Your Ref:
Our Ref: EP/17/09/
Please ask for:
Mr J Smith

Three bedroom detached house in the land North of Seaside Cottage
Land North Of Seaside Cottage South Strand East Preston

At the meeting held on Monday, 23rd February, the Planning Committee of this Council wished to comment on this Application as follows. ☐

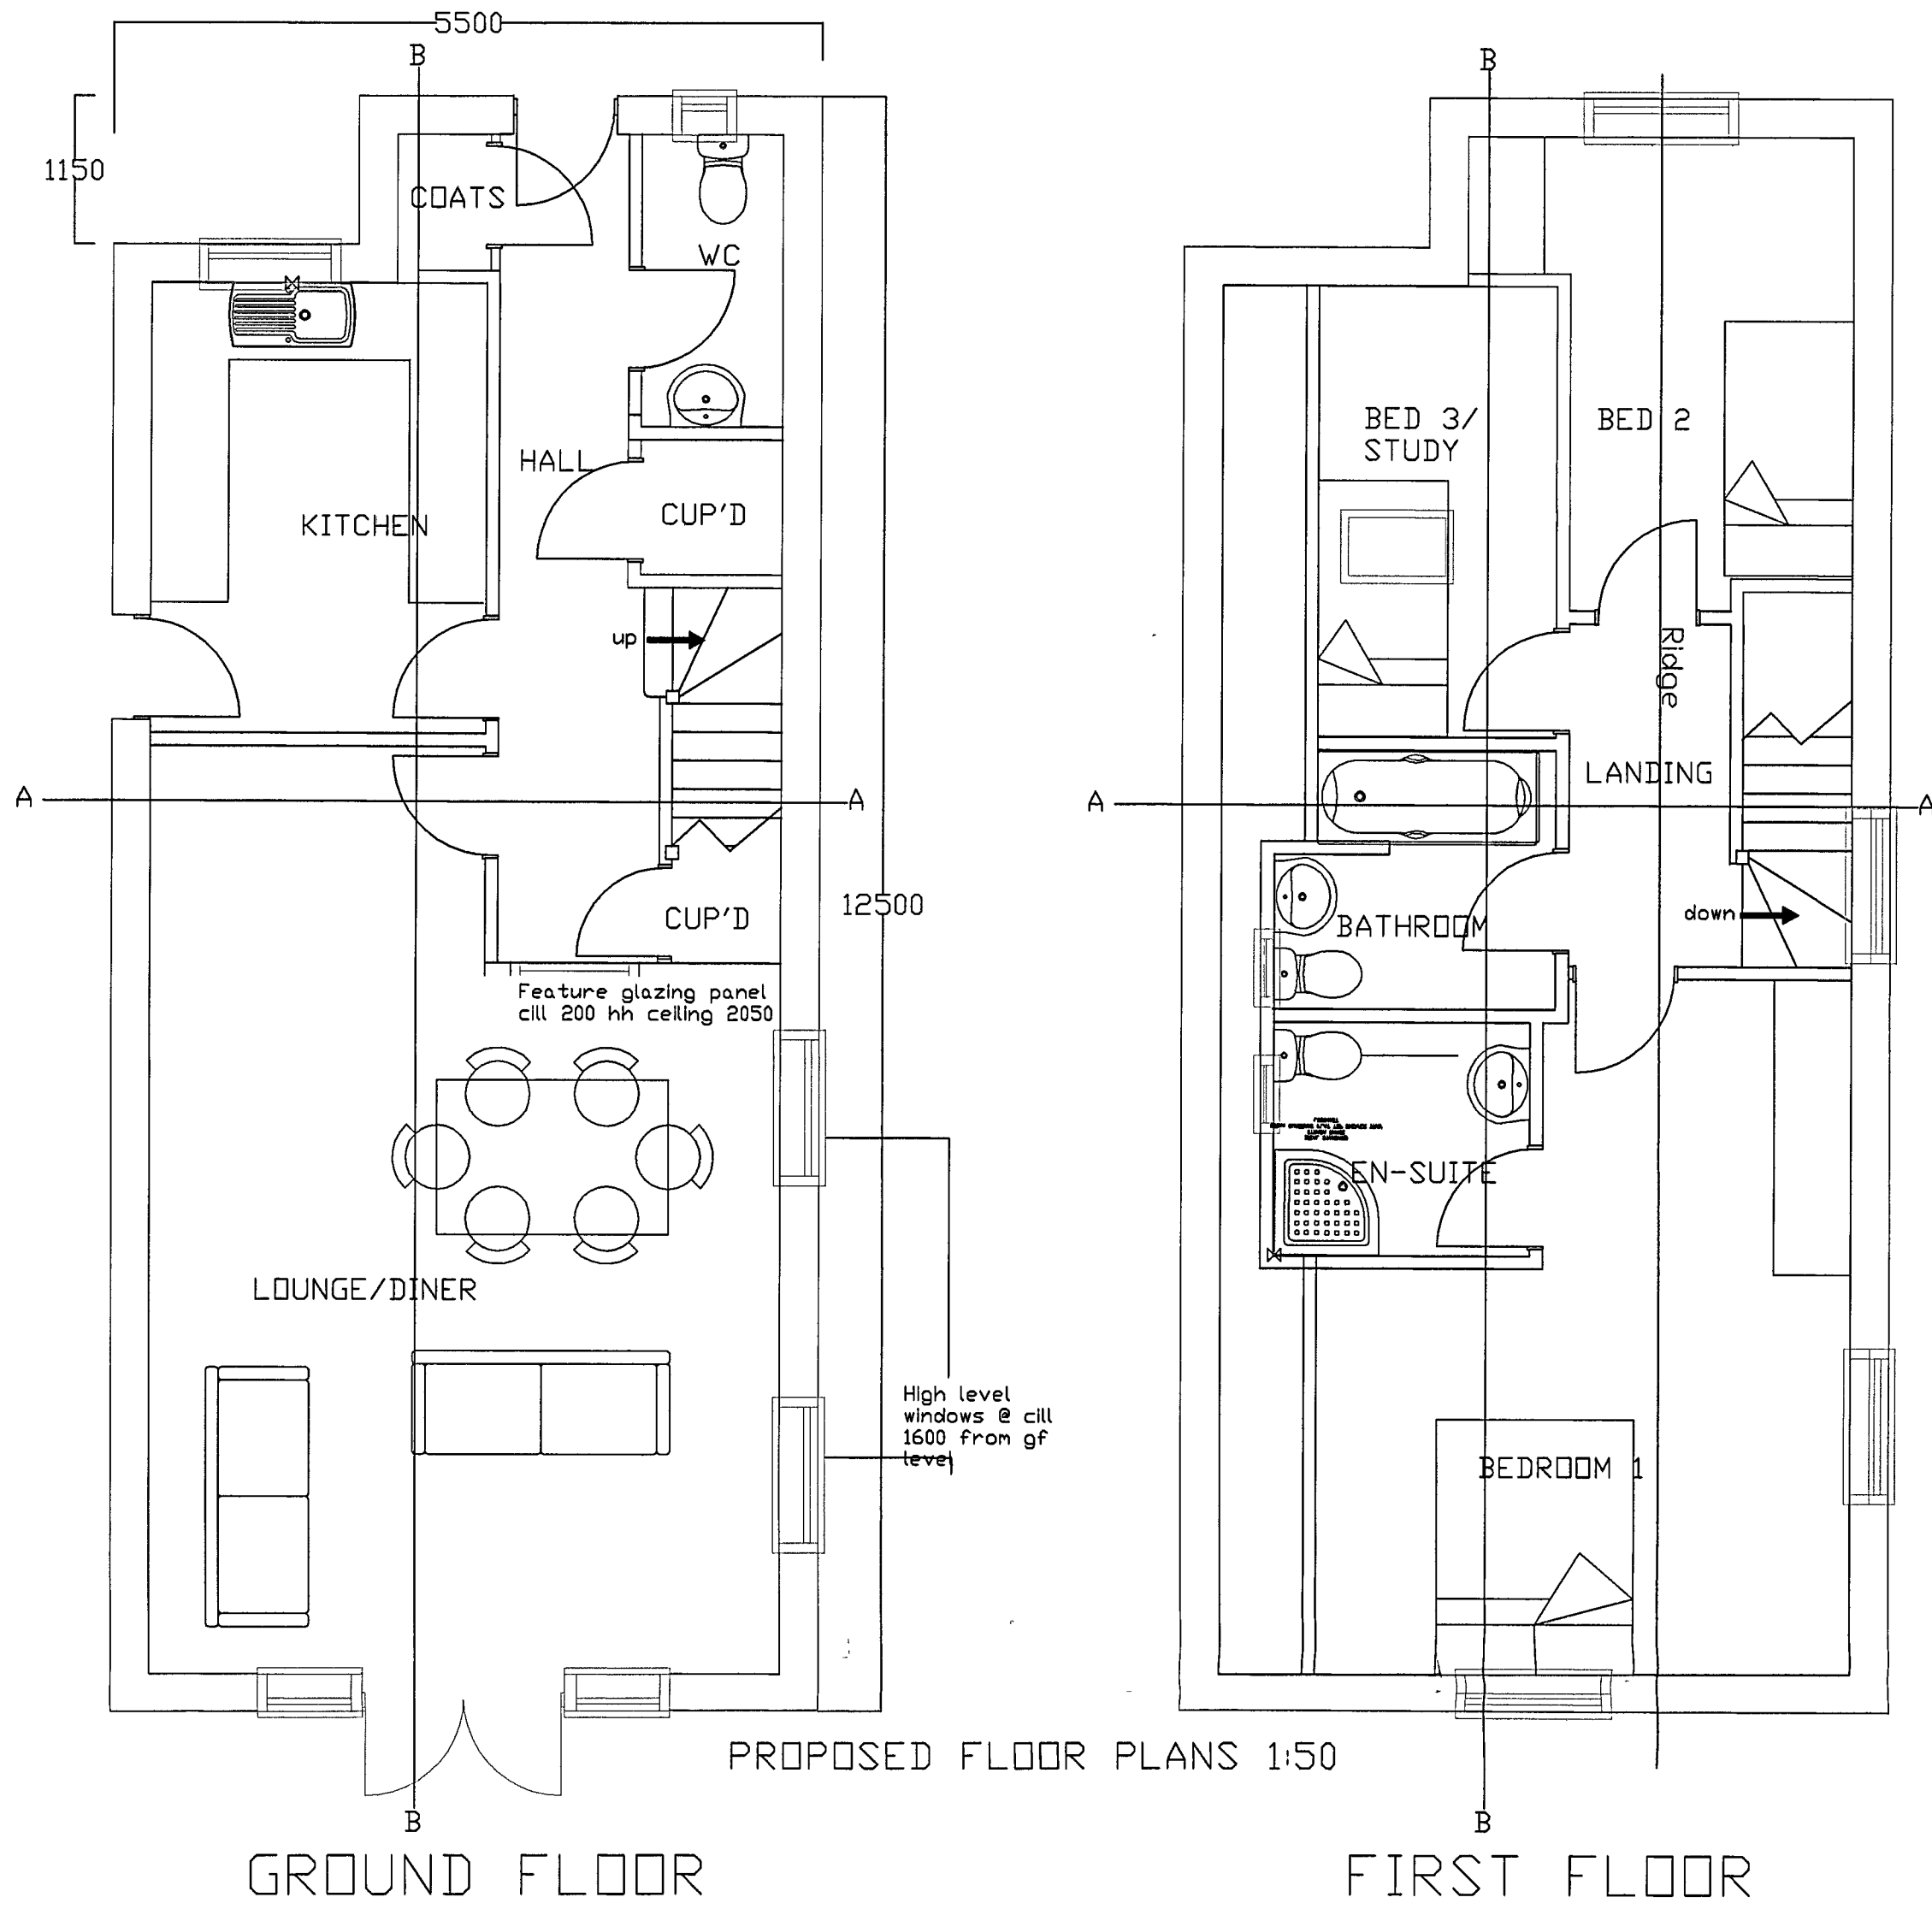
☐ *1. The proposed development is located in the area known as Angmering-on-Sea which is a private estate characterised by mainly detached houses built on relatively large plots with large gardens. The proposed in-fill development would result in the unacceptable loss of an important part of a garden and would have a detrimental impact on the character and appearance of the locality.* ☐

☐ *2. The site by reason of its size is considered unsuitable to accommodate a dwelling and private amenity space without damaging the character of the area. The cramped nature of the dwelling would also be detrimental to neighbouring outlook and would harm the existing street scene, contrary to Policies G1, G5 and B1 of the West Sussex Structure Plan and GEN 7 of the Arun District Local Plan.* ☐

☐ *3. The proposed development would be visually intrusive and un-neighbourly and would have a materially adverse effect on the residential amenities of adjoining properties.* ☐

☐ *4. The development would lead to overlooking, loss of light and adversely affect the privacy and quiet enjoyment of neighbouring properties contrary to Policy DEV1 of the West Sussex Structure Plan and GEN7 of the Arun District Local Plan.* ☐
